14th November 2013

Council Office Extension Ref: N6/2013/1938/MA

Title Proposed Sections

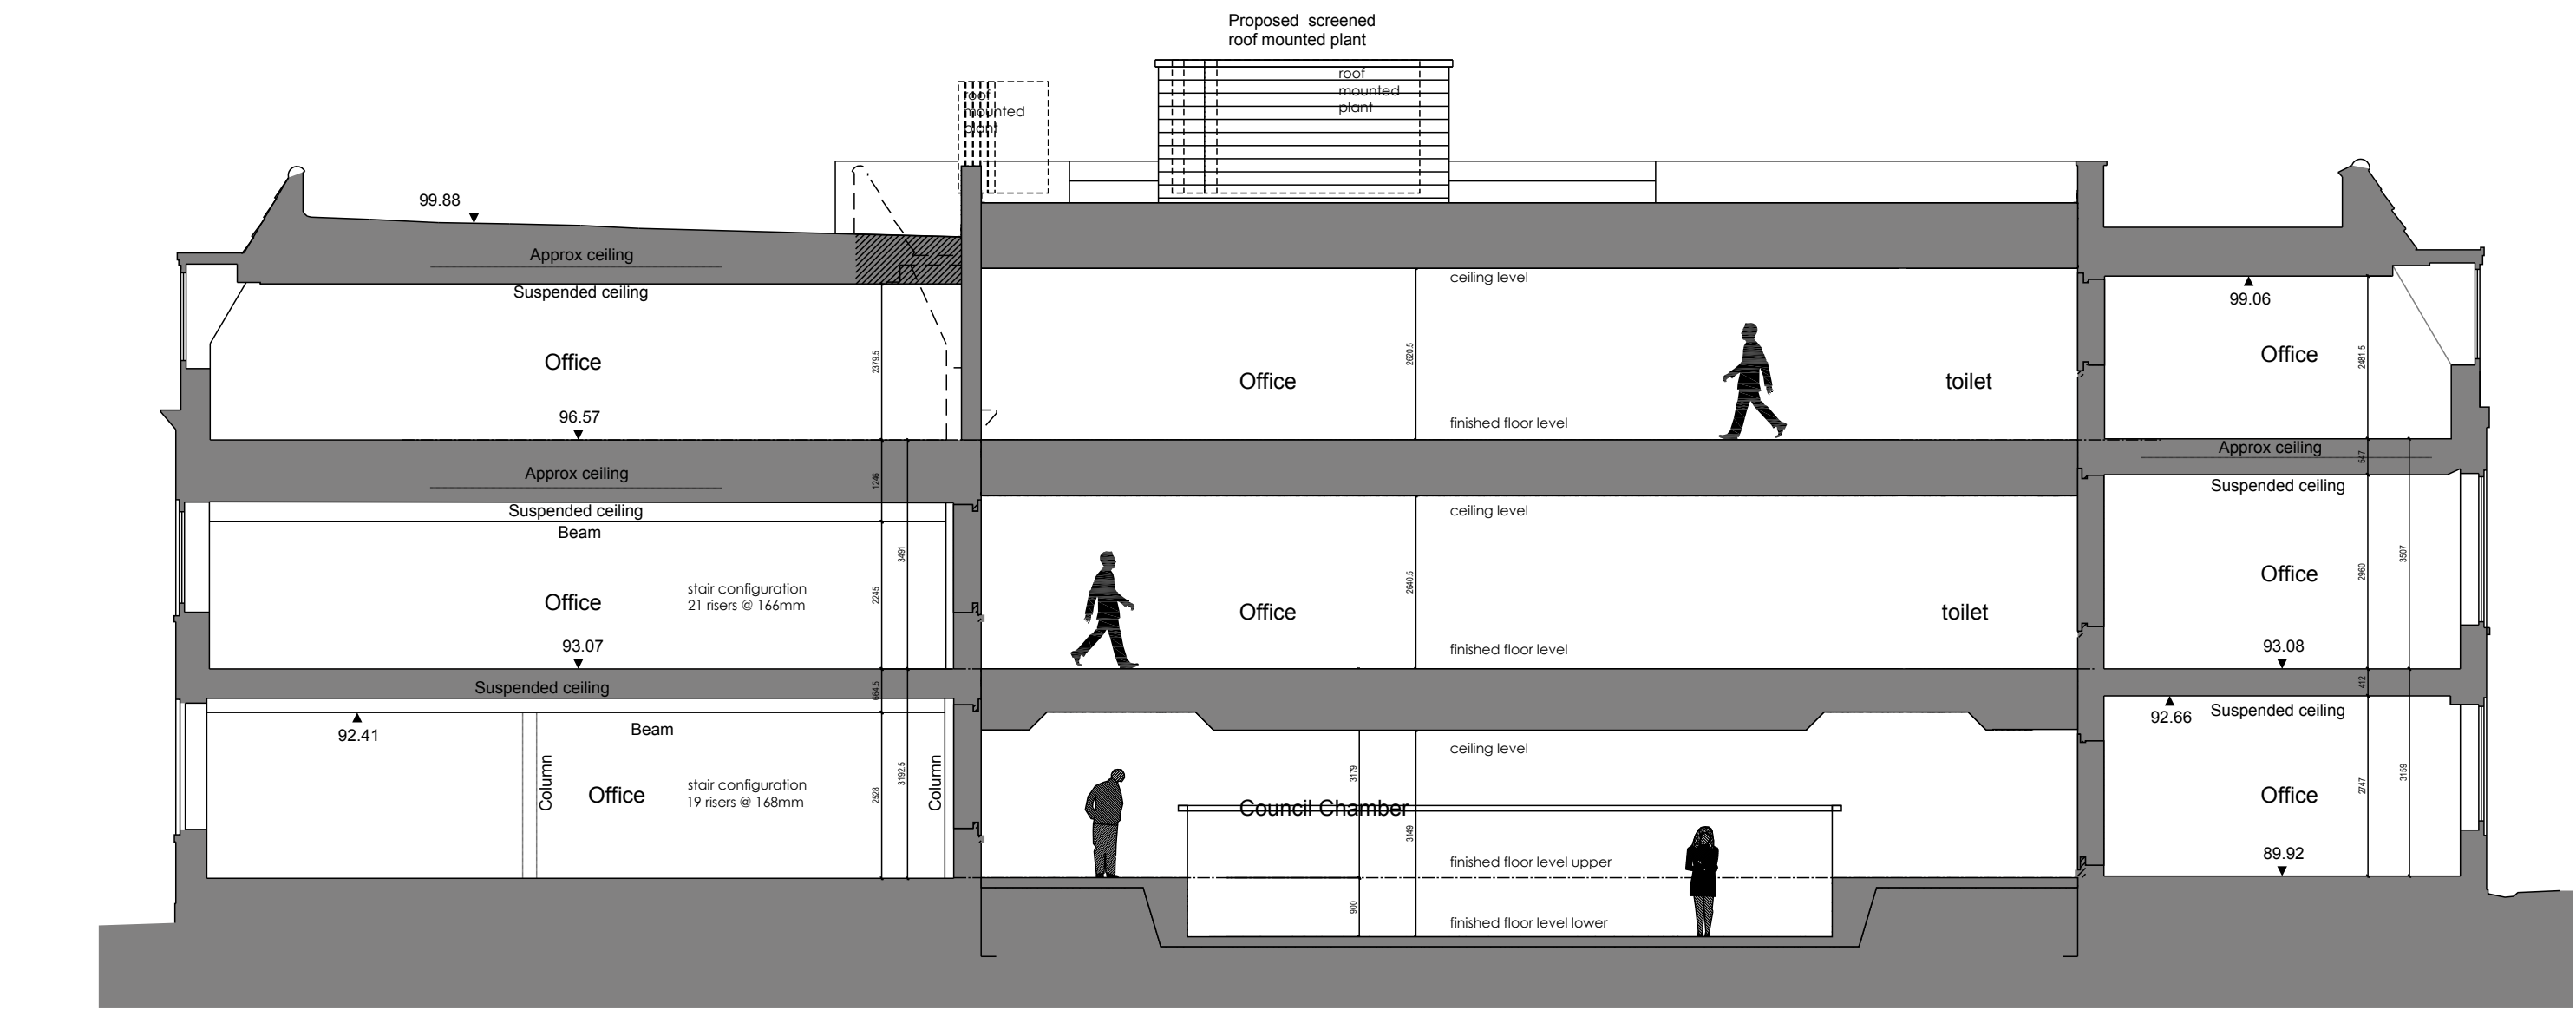
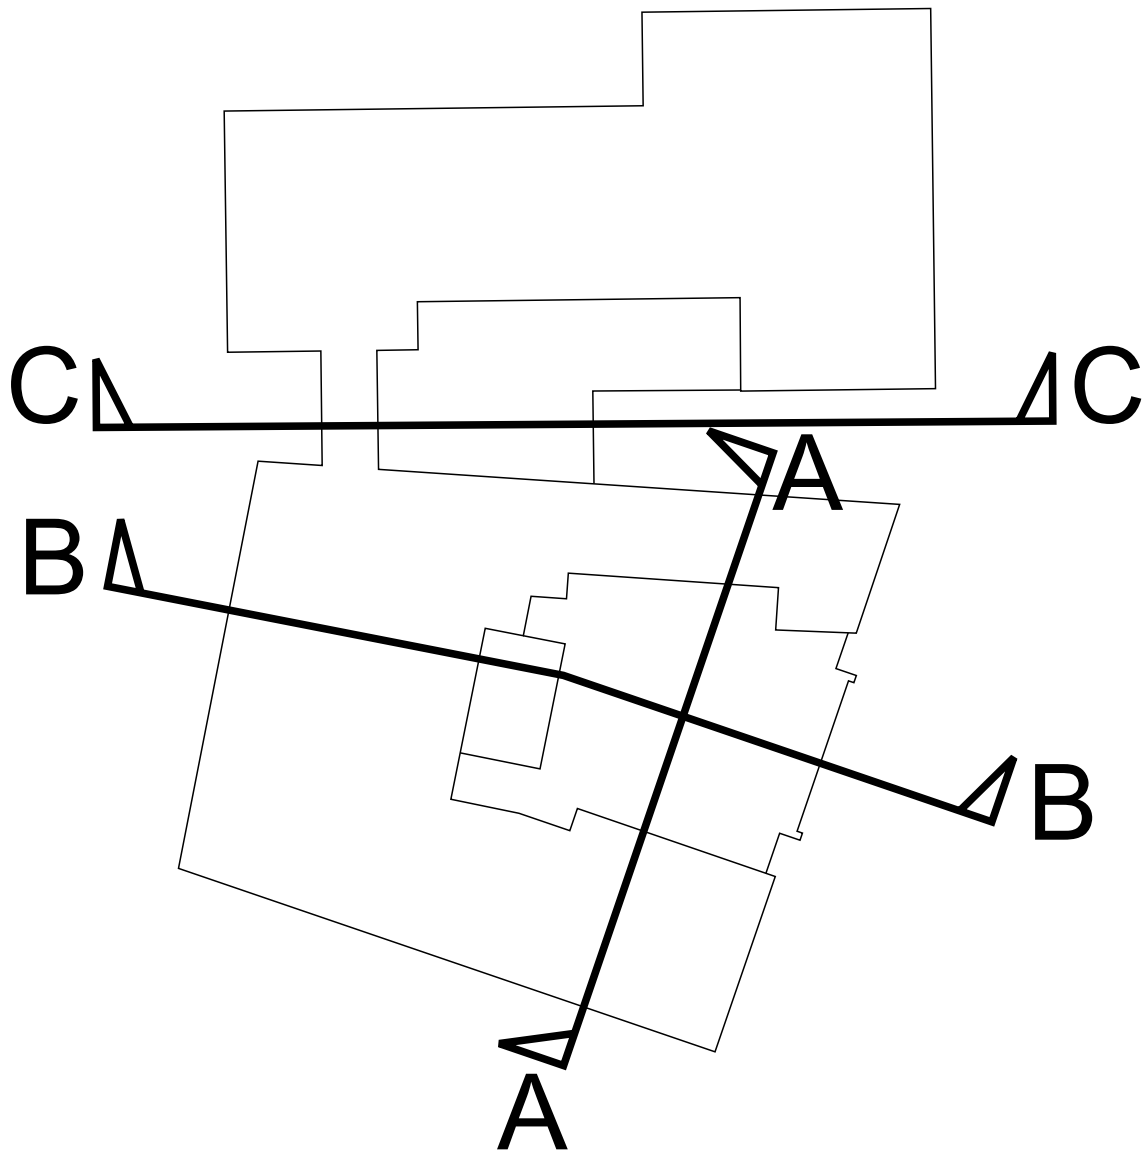
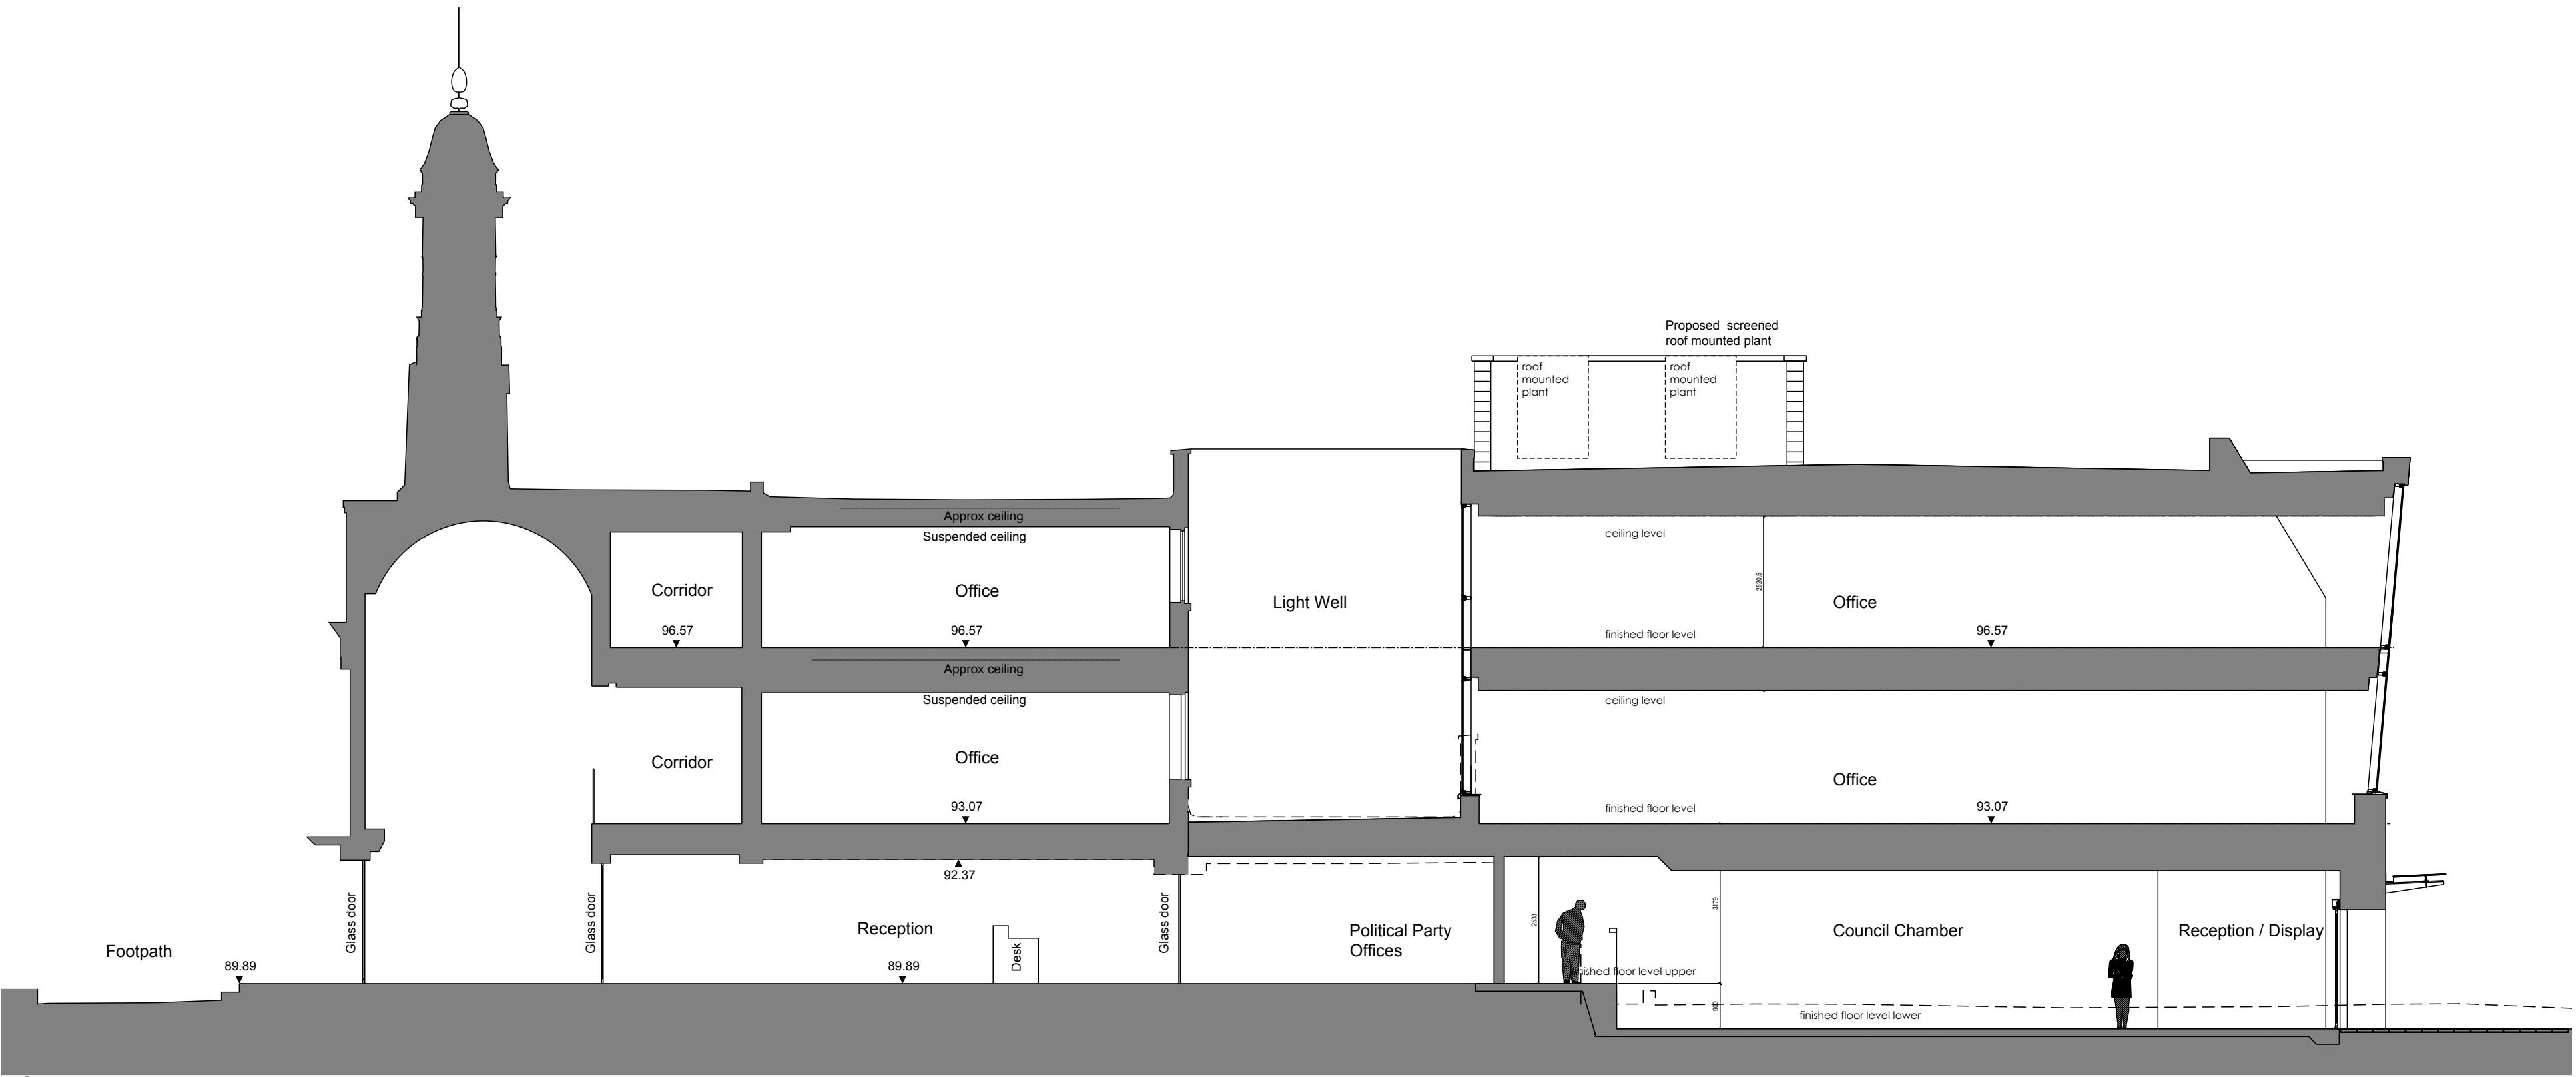
- 3) The internal layout does not appear to be fit for purpose. There is insufficient space for the current number of employees and totally inadequate space for the storage of documents. How will you accommodate addition staff in the future should the need arise?

Title Proposed Materials

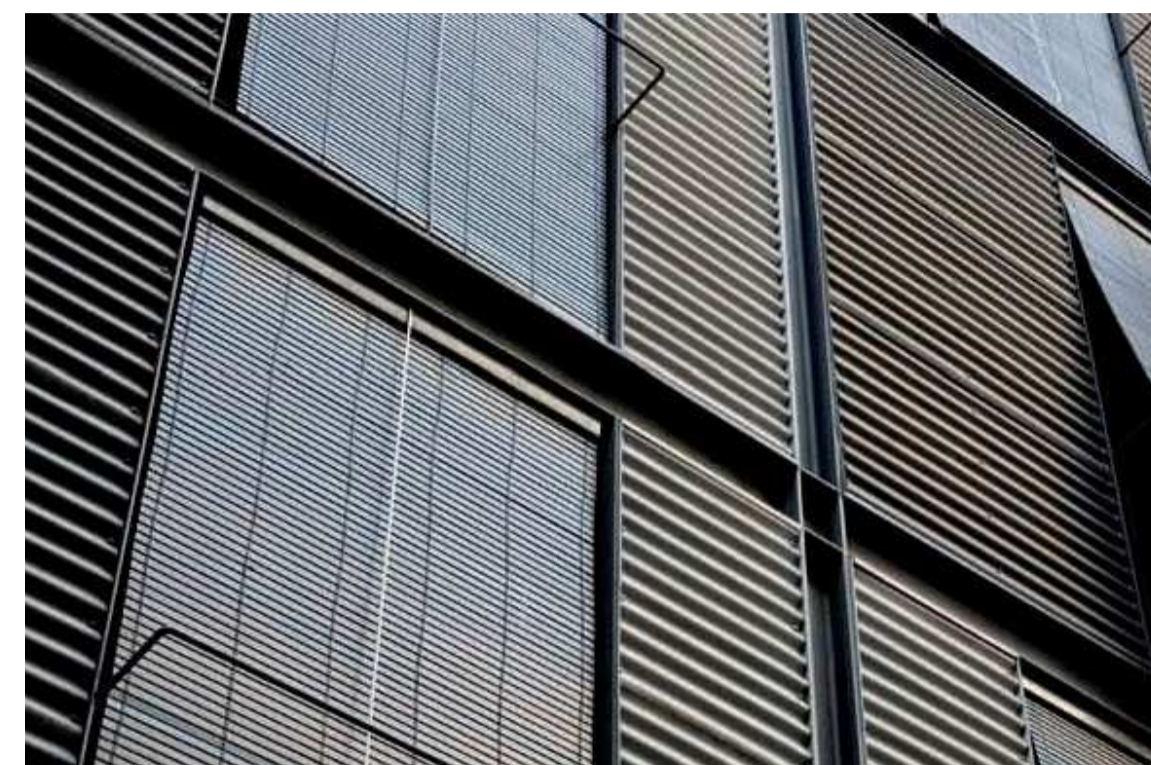
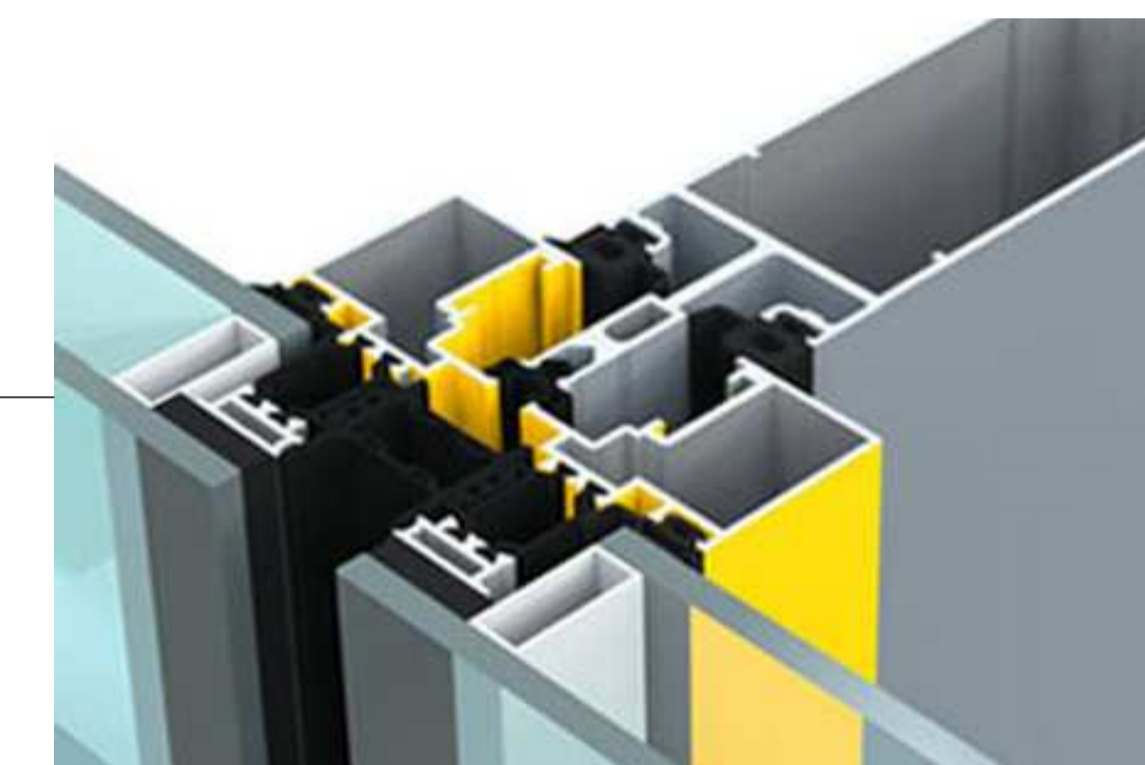
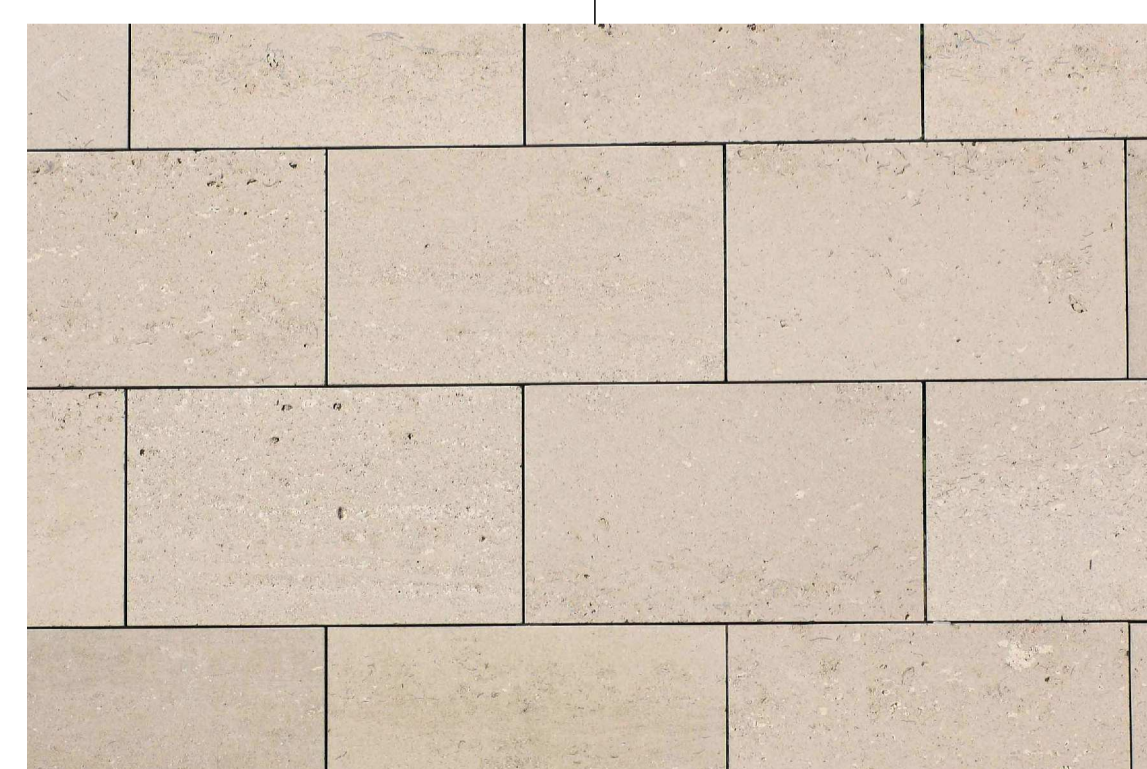
- 2) The angular glass structure is ugly, out of scale and detracts from Cecil Elsom's award winning building. It does not 'respect the materials and setting' nor is it 'subservient to the existing building' which are conditions that the Council impose on all other residents and businesses. The Council should be leading by example, not flouting its own planning rules.

The large glass entrance is still completely out of character with the existing building and those buildings forming the central core of the town, for which Welwyn Garden City is highly regarded. This is an award winning iconic building in the centre of the town so I should like you to explain on what basis you can justify something which is so out of keeping. The Council still does not appear to have learnt any lessons from their past mistakes and this seems to be heading for yet another ill-conceived disaster.

Planning rules exist to prevent inappropriate development and the preservation of the Conservation area in Welwyn Garden City is dependent on them being rigorously applied. The current plans still fail to satisfy the requirement that all development in the Conservation area must be appropriate in terms of design and materials and should be subservient to the existing building.
